**DELEGATED DECISION TO DETERMINE PLANNING APPLICATIONS**

Reference No:	<b>2025/62/92412/W</b>
Site Address:	16, Banks Avenue, Golcar, Huddersfield, HD7 4LZ
Description:	Erection of first floor rear extension (within a Conservation Area)
Recommending Officer:	Joanna Rednall

**DECISION – CONDITIONAL FULL PERMISSION**

drg title
Proposed Elevations

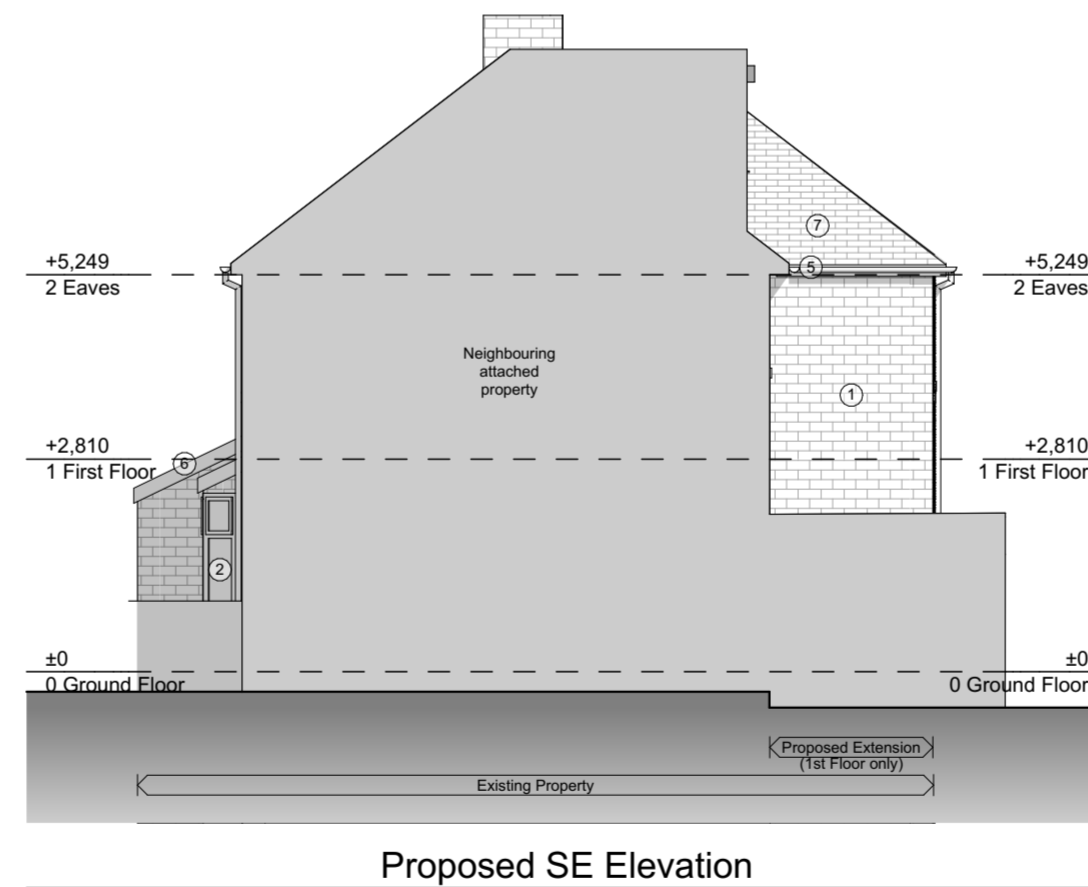
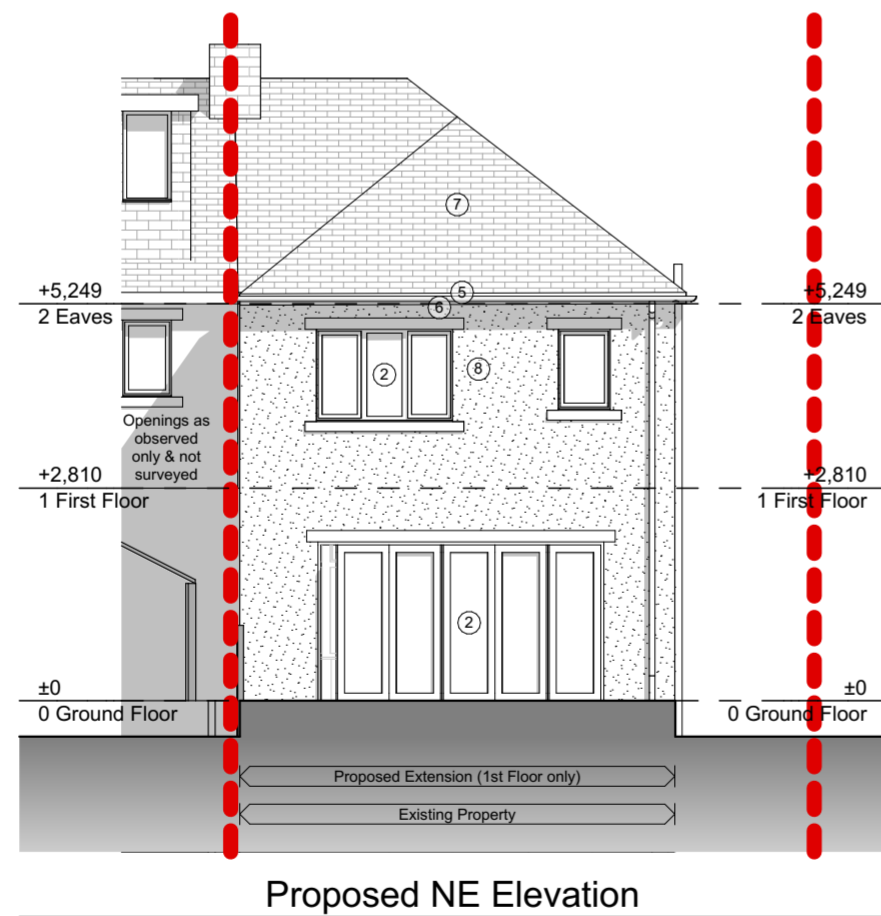
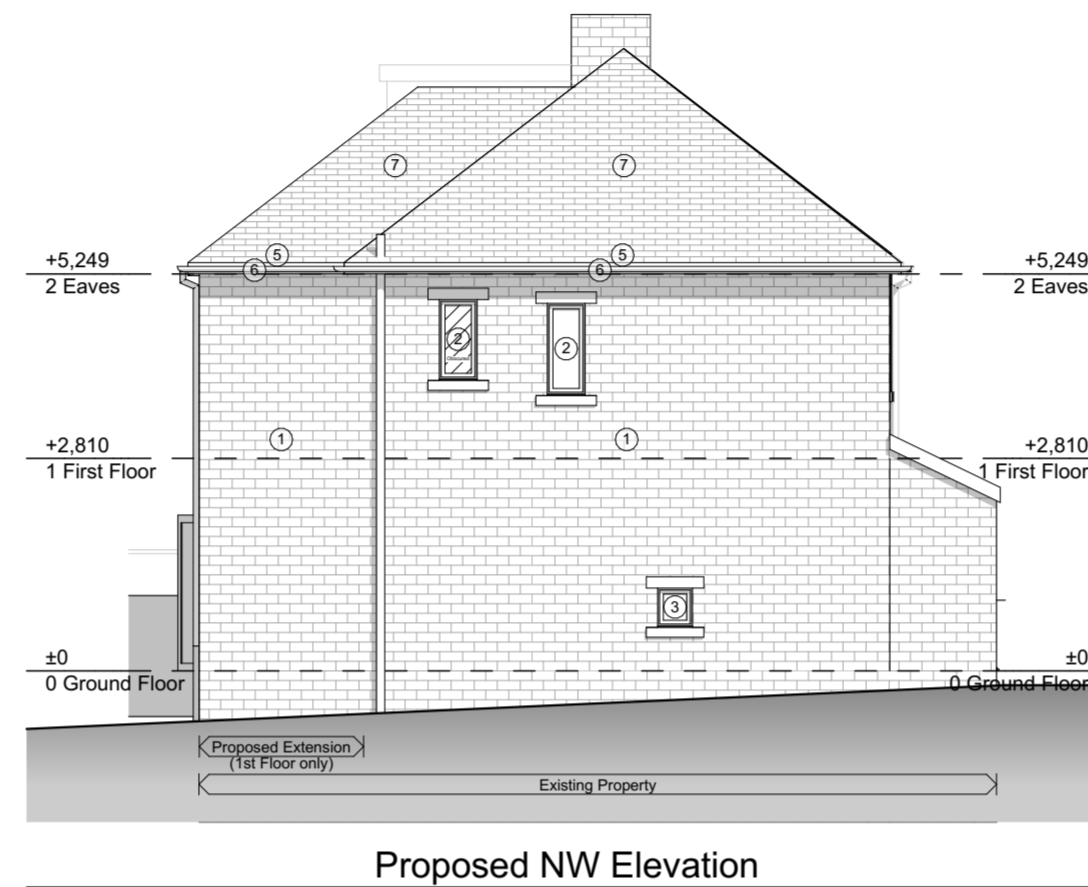
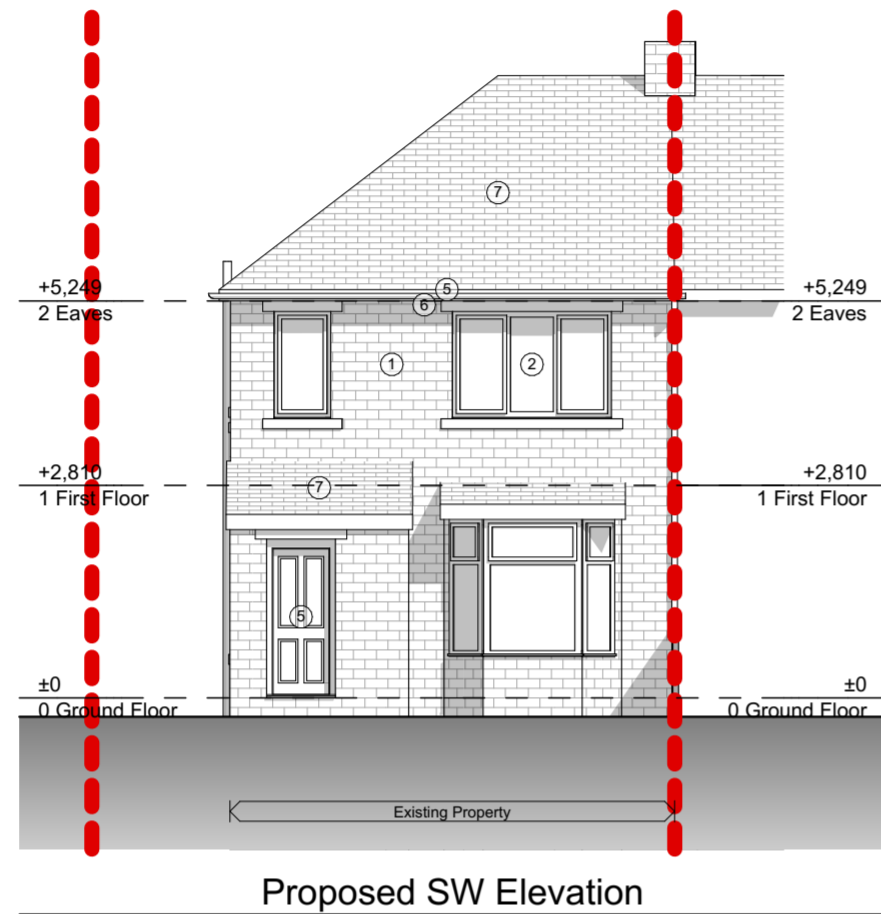
Officers contacted the applicant's agent about the proposed use of render on the extension. The agent confirmed by email on 10 November 2025 that materials matching the existing house would be used instead.

During the assessment, concerns were raised with the applicant's agent regarding the proposed use of render as an external finishing material. Although positioned to the rear, the use of render would not reflect the traditional brick and stone material palette characteristic of the locality and would be partially visible from neighbouring properties and the wider area in which the Conservation Area is experienced. In response, the agent confirmed via email that the external materials can be conditioned to match those of the host dwelling. It is therefore considered that, subject to a condition requiring materials to match the existing property, the proposal would accord with the aims and objectives of Policies LP24 and LP35. Accordingly, the development is not considered to result in harm to the character or setting of the Conservation Area.

- Notwithstanding the plans submitted, the external walls and roof of the development hereby approved shall in all respects match those used in the construction of the existing building and be retained thereafter.
